Application for a Non-Material Amendment Following a Grant of Planning Permission

Demolition of existing bungalow and replacement with new Passivhaus bungalow, adjacent double garage with covered link.

21/01982/FUL

Removal of plinth brickwork and soldier course.

**AS CONSENTED UNDER REF. 21/01982/FUL**

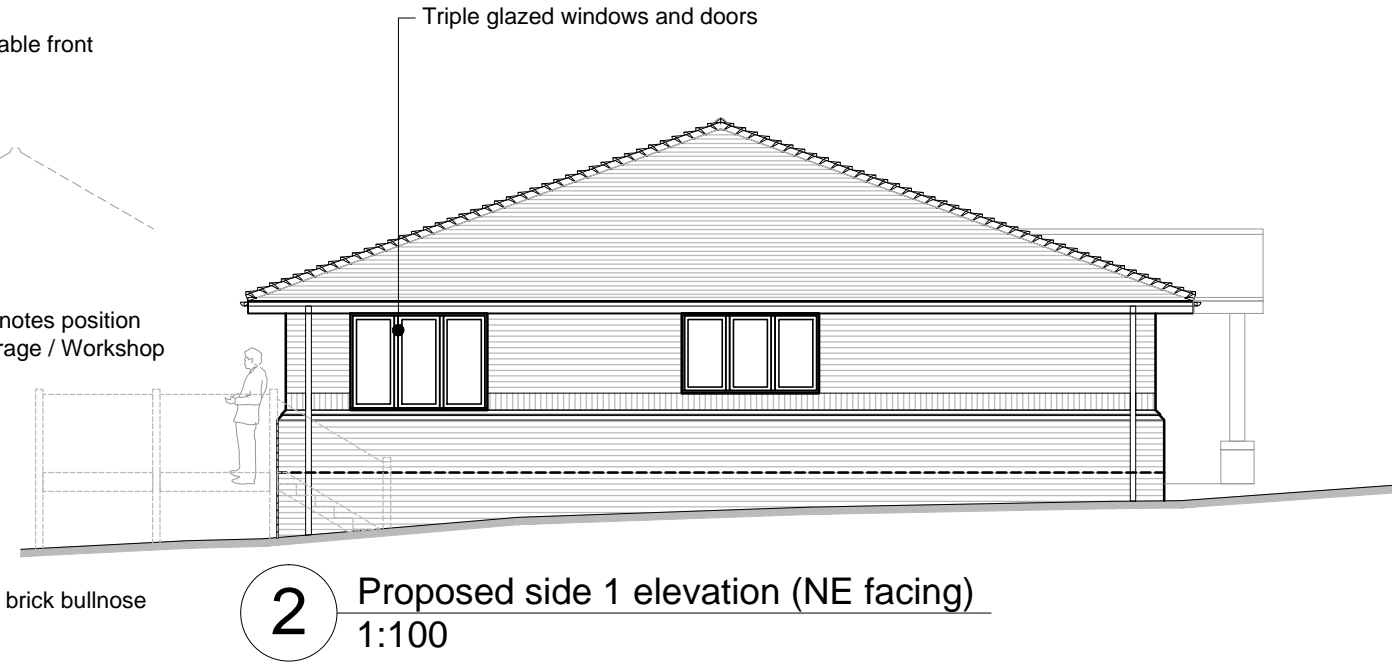
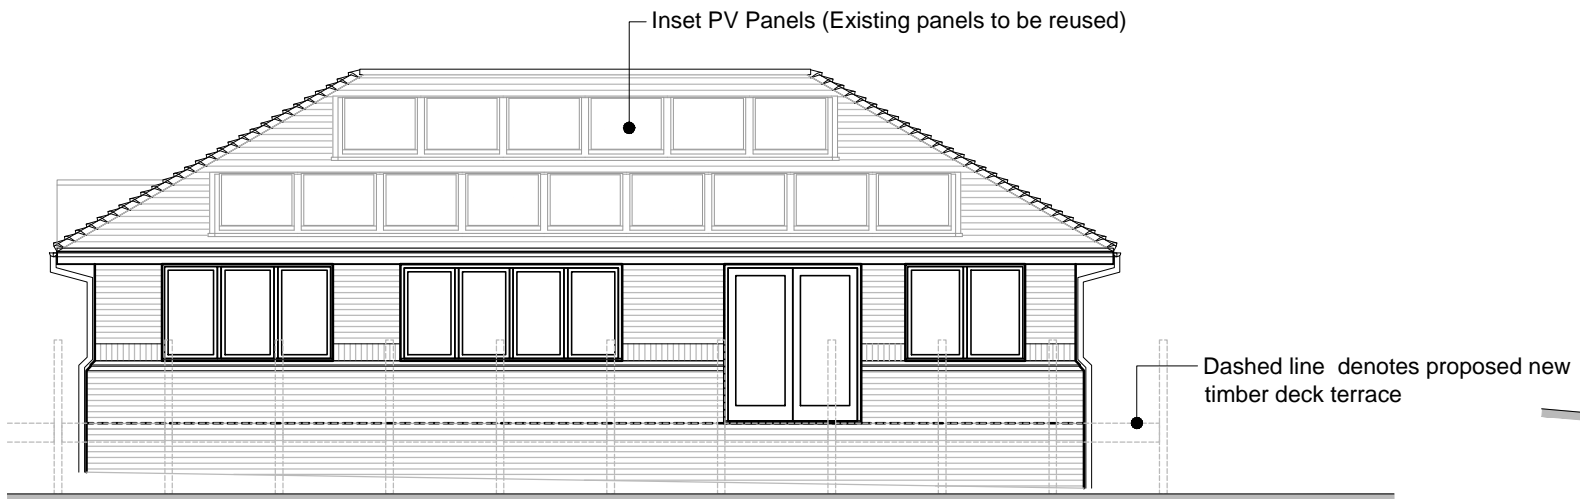
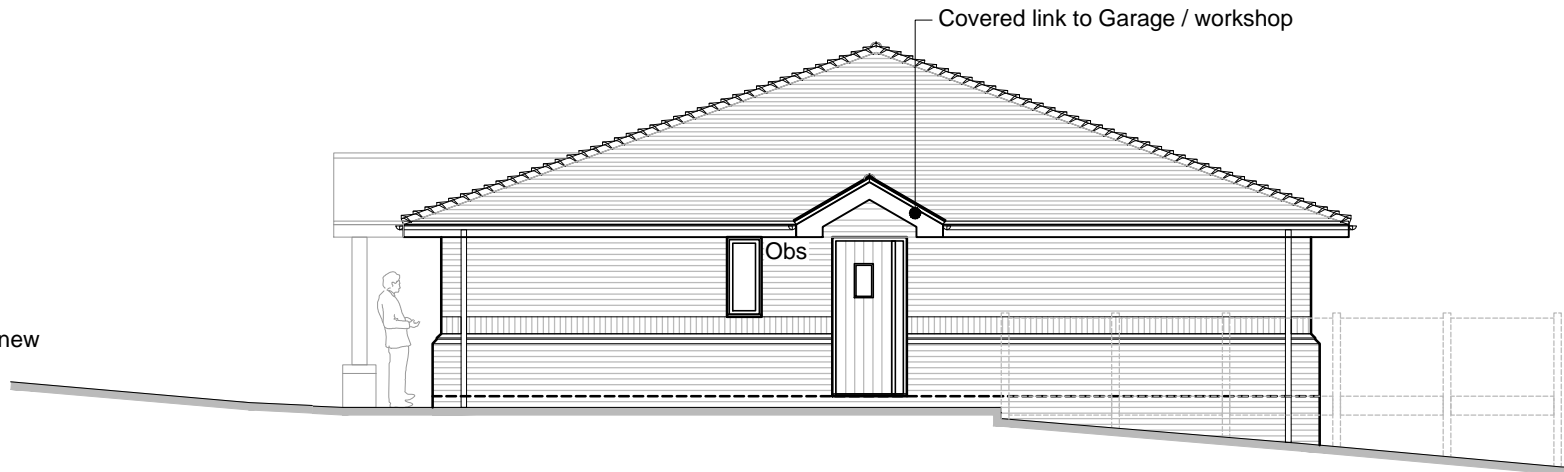
Simplification of proposed detailing and making project affordable to client budget.

Old plan/drawing numbers

E2402 015-B Proposed elevations-House

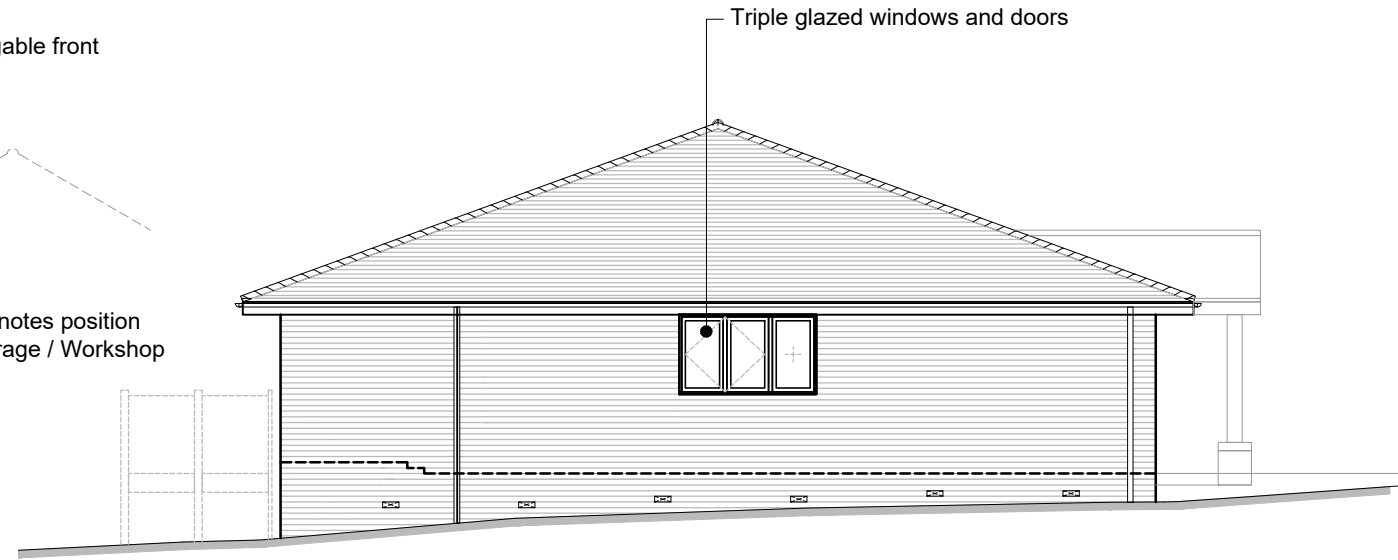
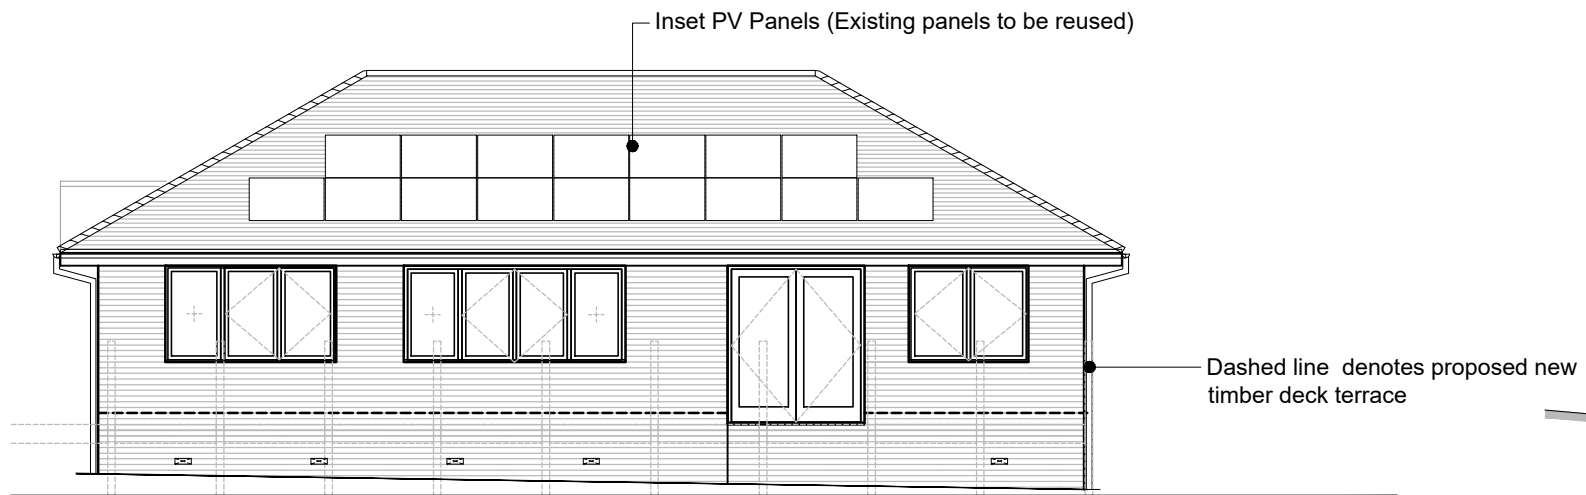
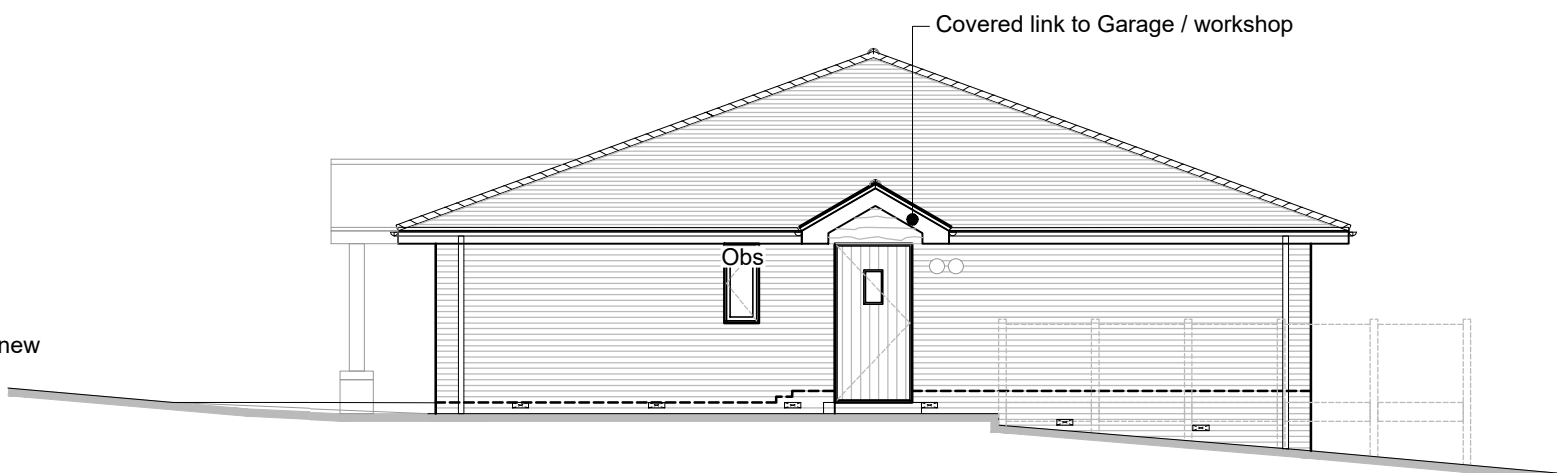
New plan/drawing numbers

E2402 015-C Proposed elevations-House
